Horsley Drive Business Park - Stage 2 (SSD-7664-Mod-3)
Request for additional information

I refer to the assessment of the modification application for the Horsley Drive Business Park – Stage 2 (SSD-7664-Mod-3). The Department requires the following additional information before it can finalise its assessment:

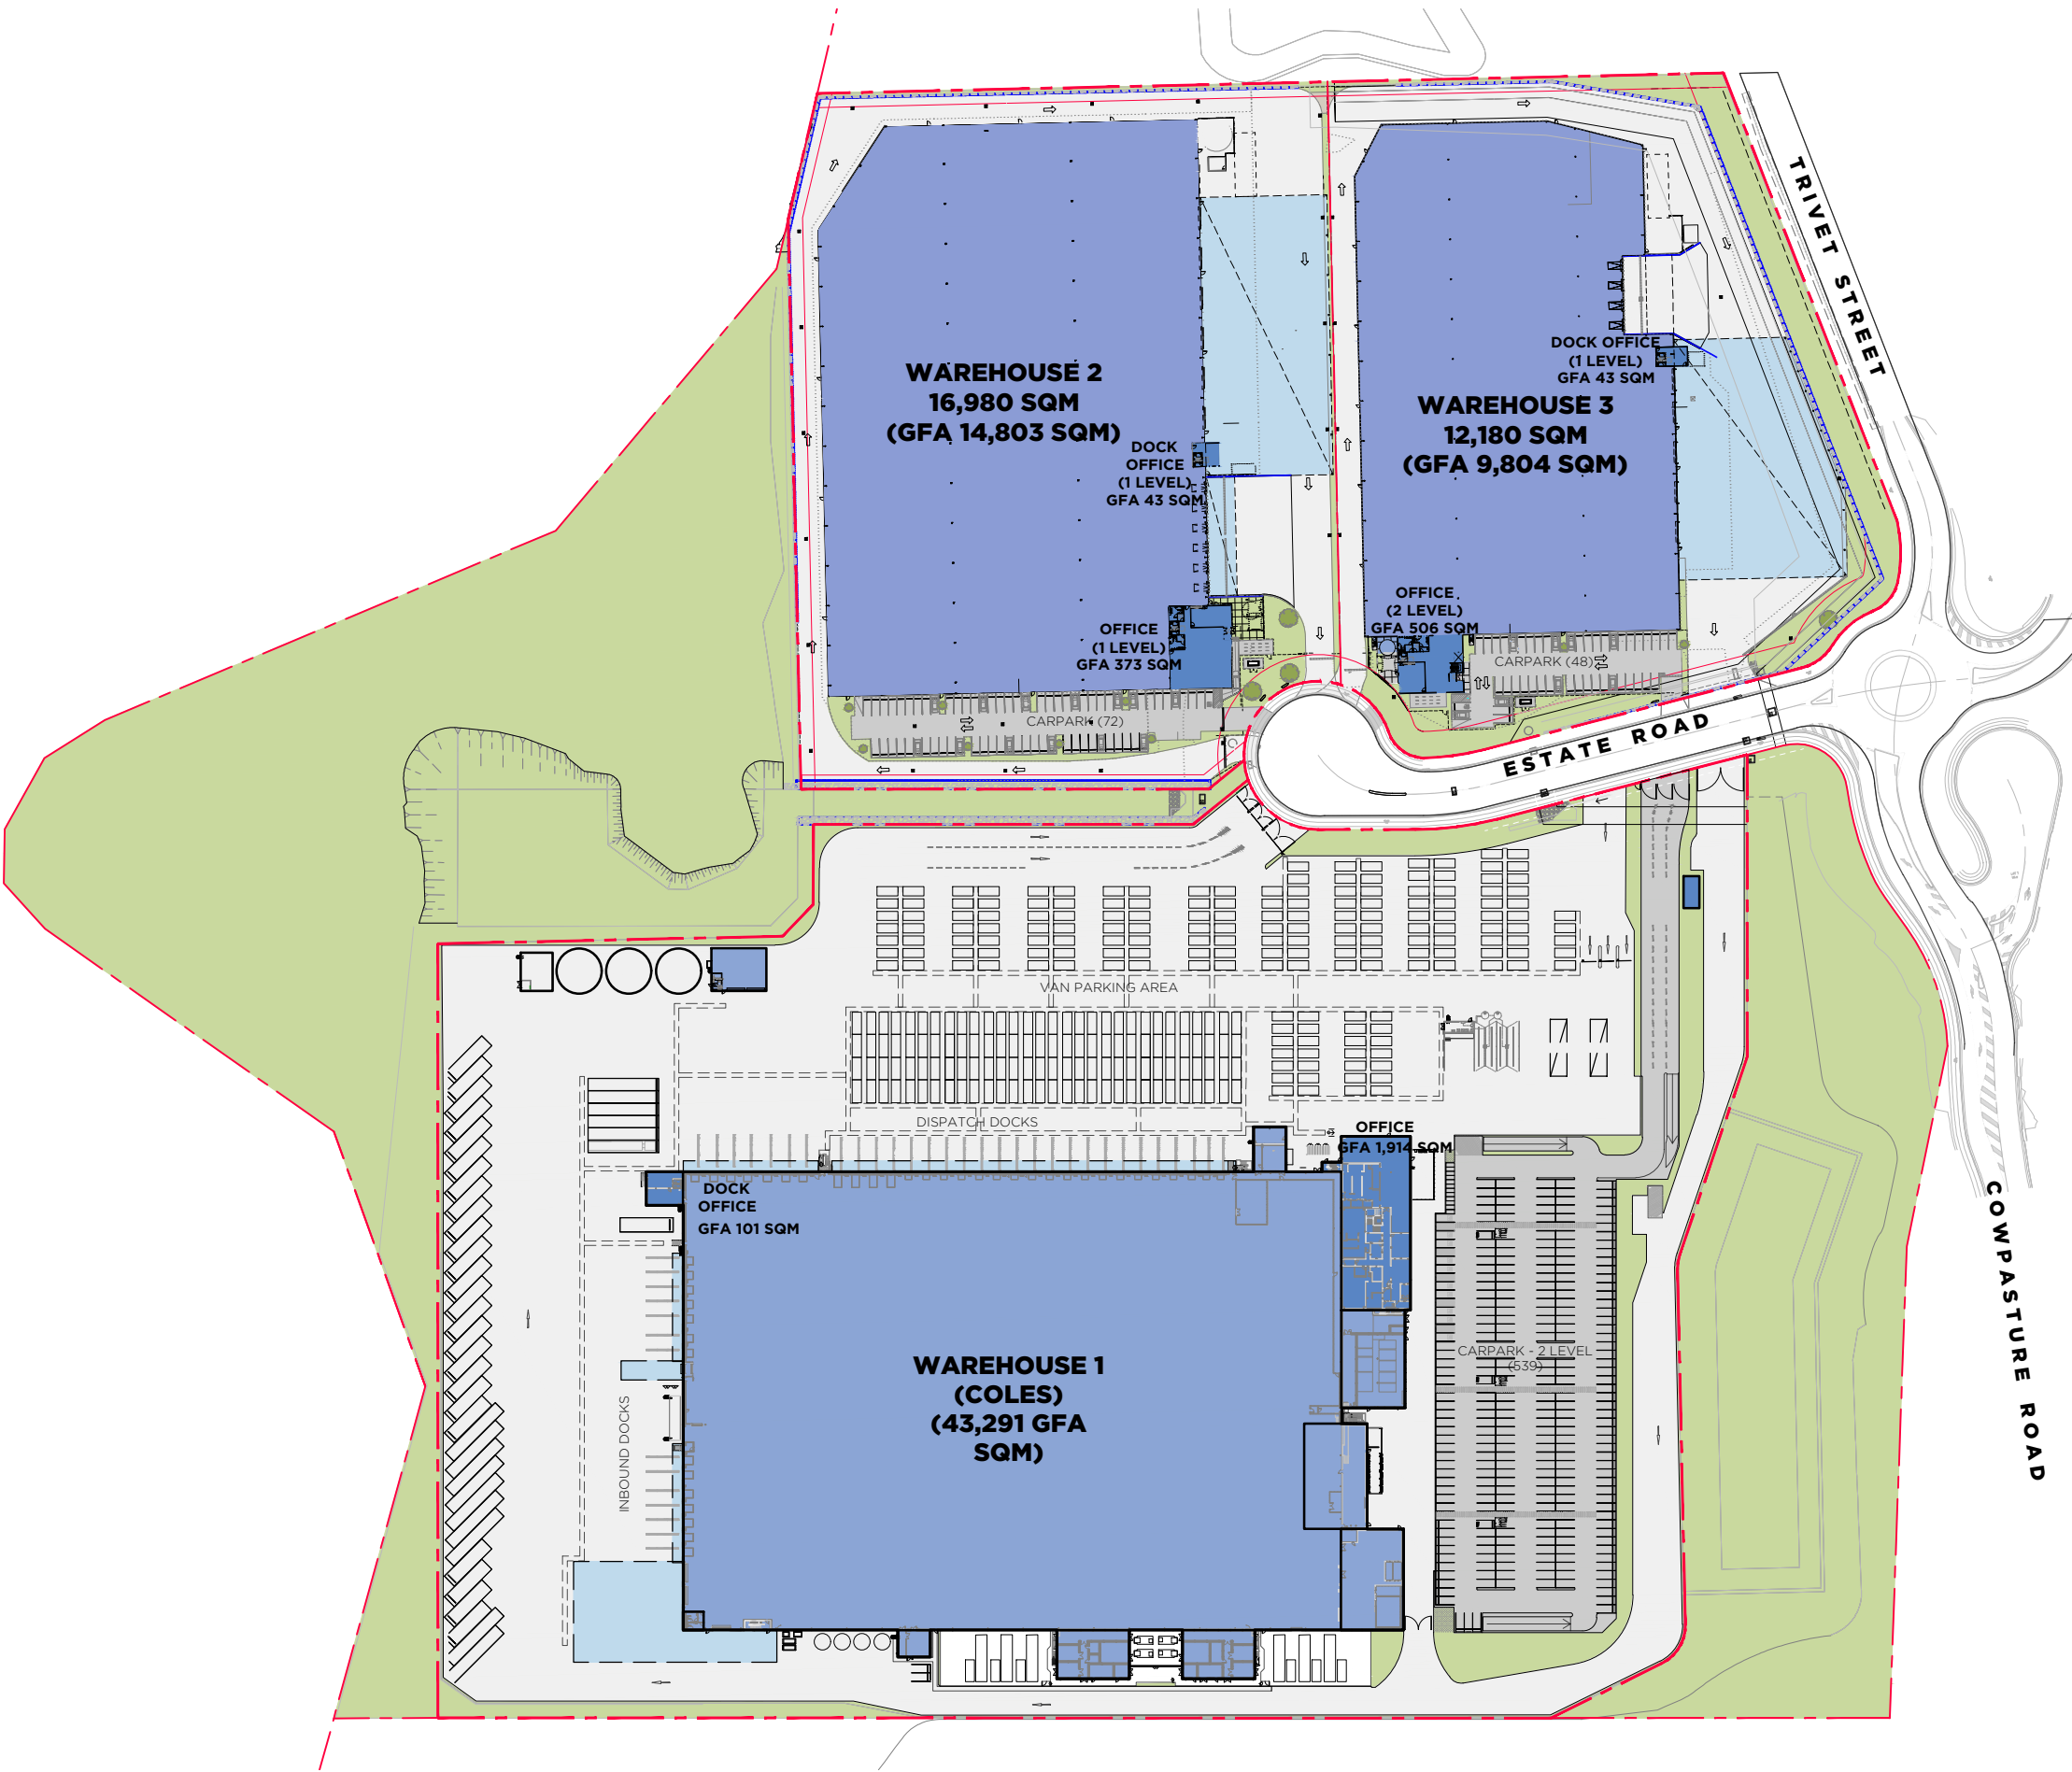
- updates to some of the current stamped plans are required to ensure consistency with the amendments to the development sought by the modification. These include DA02 P5 and DA03 P1. It would be pertinent to review all current stamped plans to ensure consistency with the modification and resubmit as required.
- the Department also understands that you are seeking to provide amended subdivision plans for consideration prior to determination. These amended plans should be provided as part of this request.
